**Consultation Response from KC,
Highways Development Management****2024/91592 Madressah Muhammadiyah Ghausia, 111, Dark Lane, Batley, WF17 7PW****Erection of extension and alterations****Date Responded: 28-11-2024.****Responding Officer: Mark Berry.****Responding Ref: 14-11SE-3.**

This application seeks approval to the erection of an extension and alterations at Madressah Muhammadiyah Ghausia, 111, Dark Lane, Batley.

**PROPOSED SITE / ROOF PLAN**

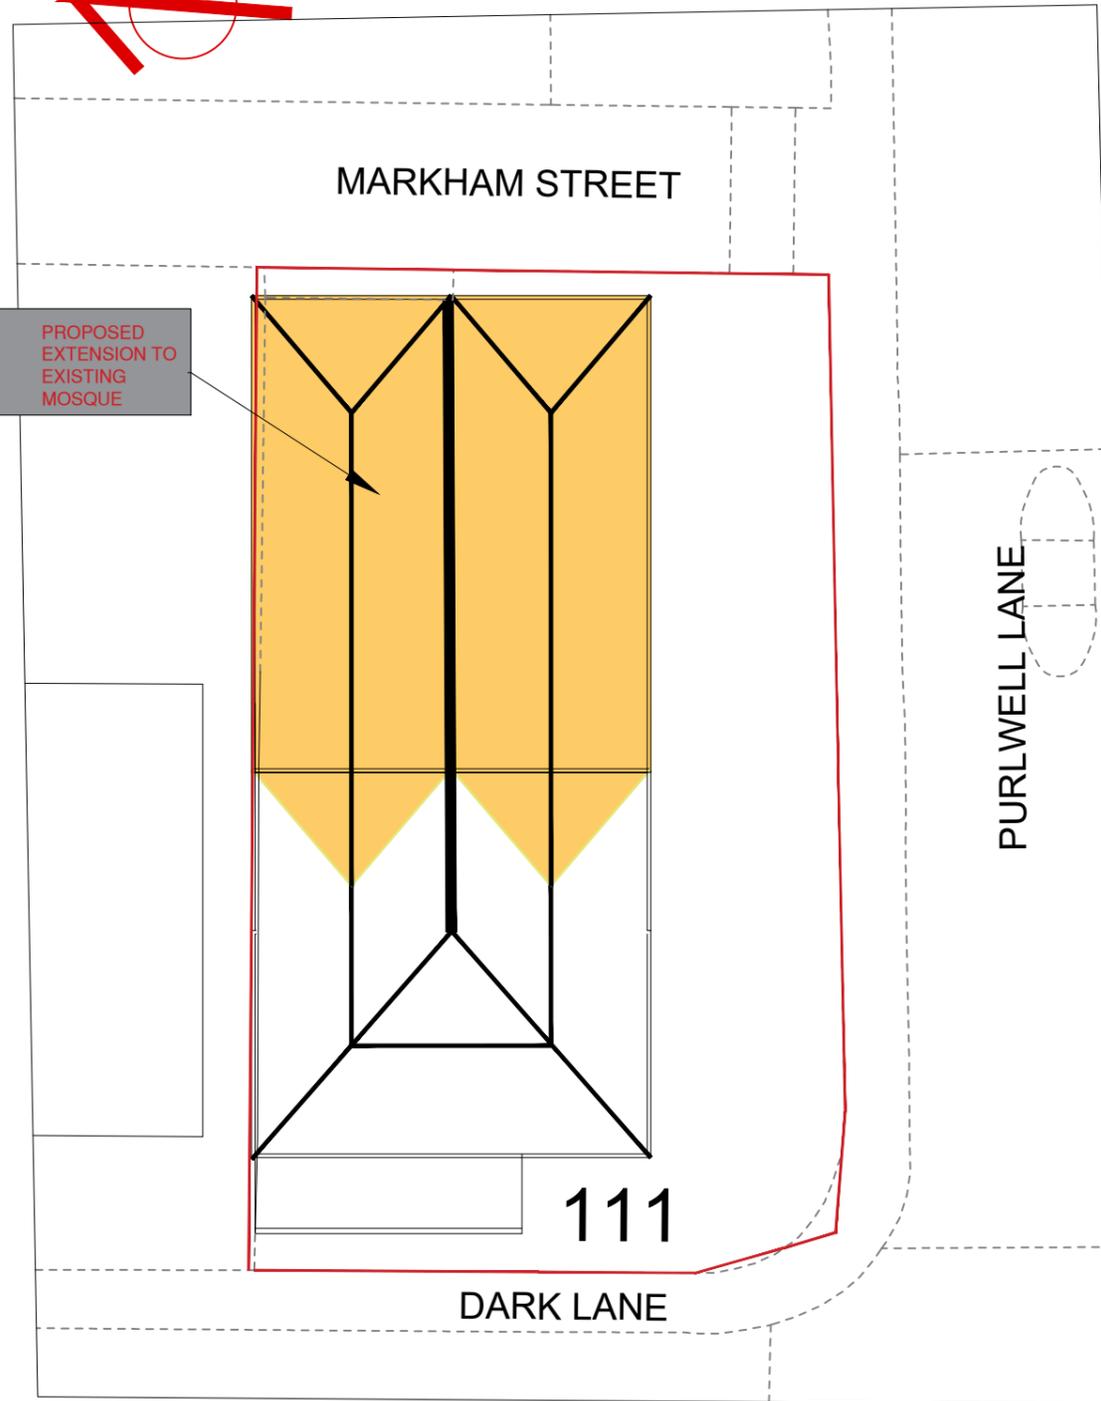
The proposal is to extend the Mosque over the existing car park to the rear.

PROPOSED BASEMENT /LOWER GROUND FLOOR PLAN

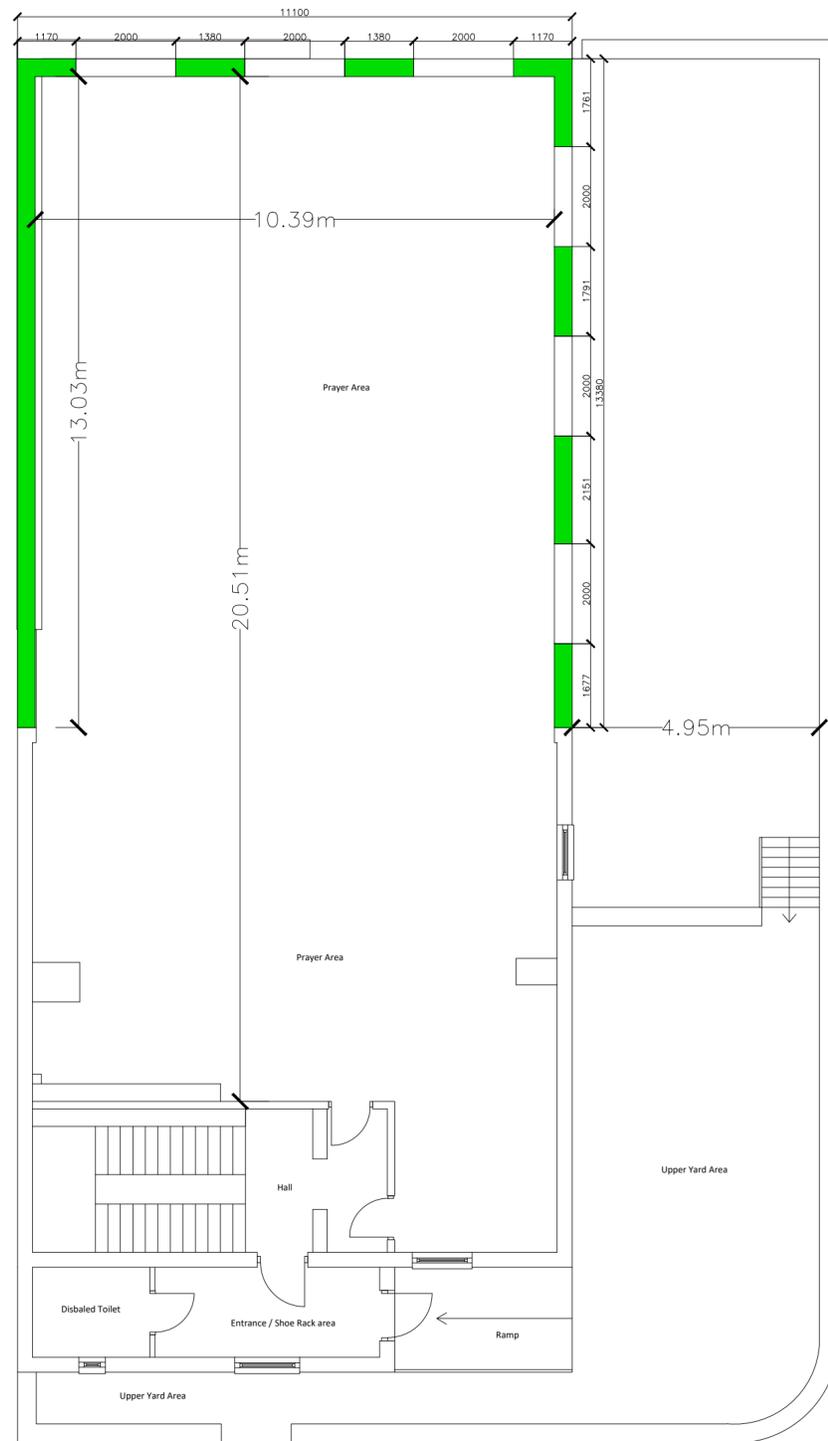
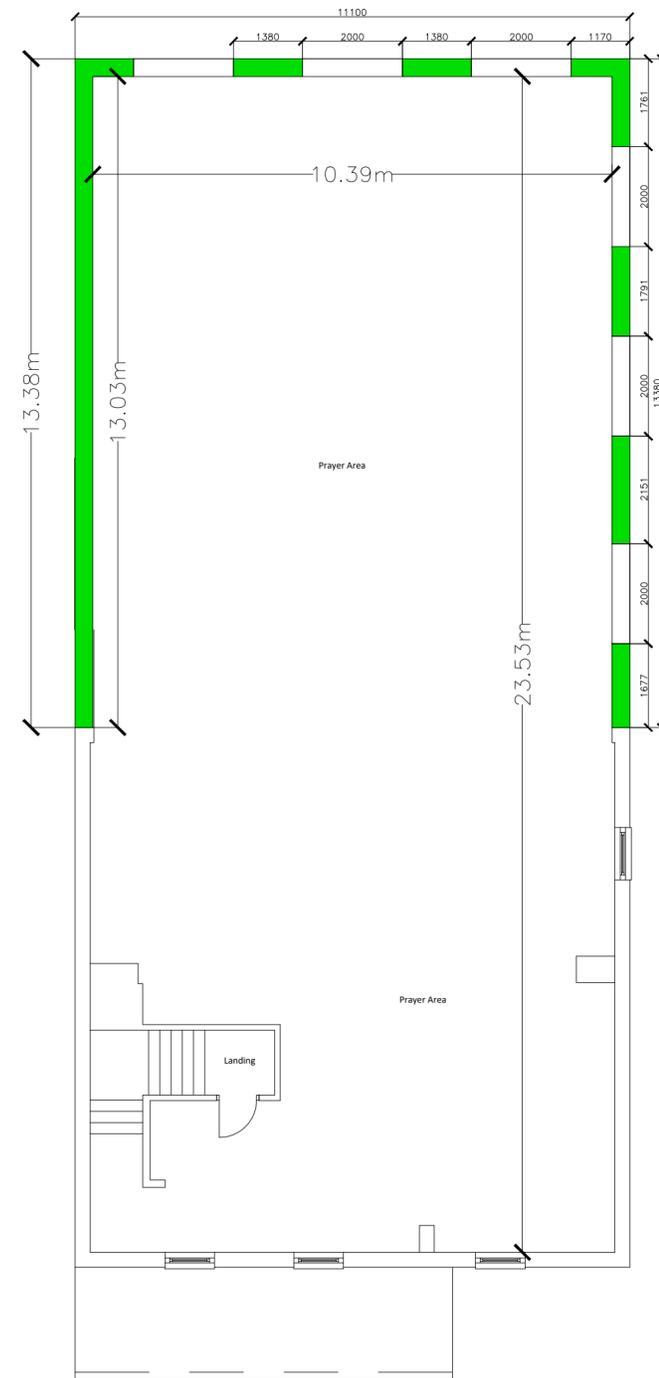
Undercroft off-street parking is shown to the lower ground floor level with access presumably from Markham Street which runs to the rear of the site. No details of the existing or proposed parking layouts are provided, however it is considered that the proposed 10 pillars required to support the extended building would reduce the capacity of the car park compared to the existing arrangements.
